Recommendation Report for Planning Permission for Works or Extension to a Dwelling

REF NO: FP/242/20/HH

LOCATION: 11 Sea Drive
Felpham
PO22 7NE

PROPOSAL: Front single storey extension with balcony over and conversion of garage.

WEST ELEVATION

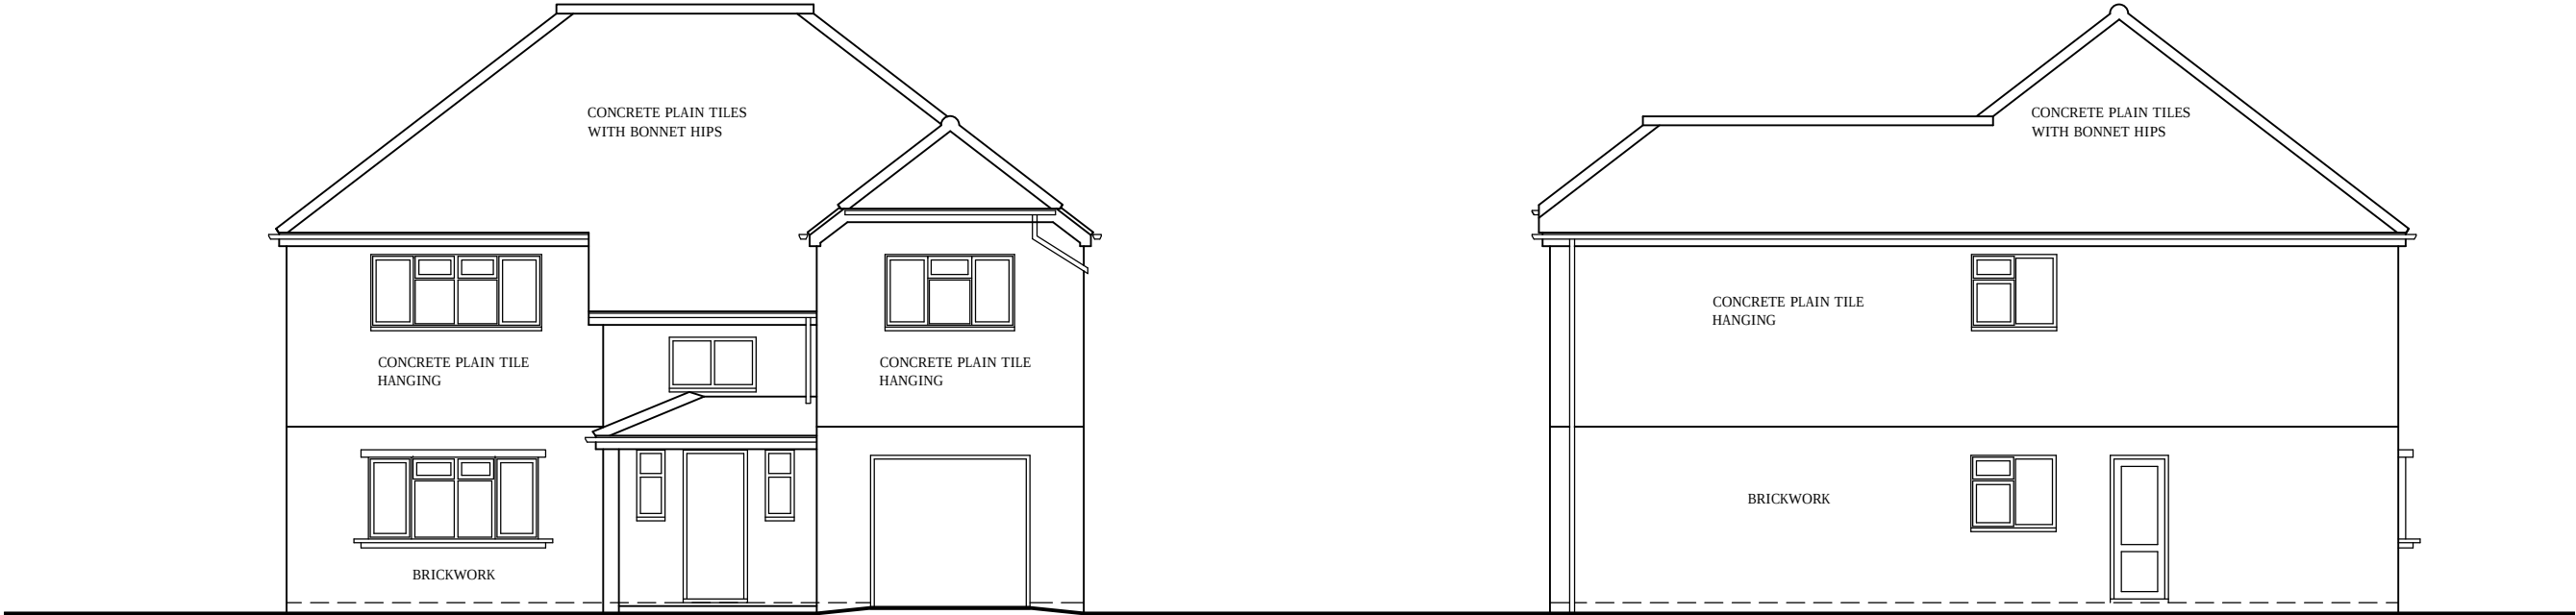
The balcony above would be accessed via the first floor bedrooms. The balcony may provide some views towards the front facing neighbouring and this would provide a significant opportunity for overlooking back towards the neighbours first floor bedroom window in the same manner as would take place from a similar rear extension. Therefore adverse overlooking could take place without an appropriate glazed balcony screen in place. A condition will be added requiring this..

Reason: For the avoidance of doubt and in the interests of amenity and the environment in accordance with policy D DM1 of the Arun Local Plan.
- 3 The roof area of the extension hereby permitted shall not be used until details of a 1.8m high obscure glazed screen for the west elevation of the extension has been submitted to an approved in writing by the Local Planning Authority and the approved screen has been put in place. The screen shall thereafter be retained in perpetuity.
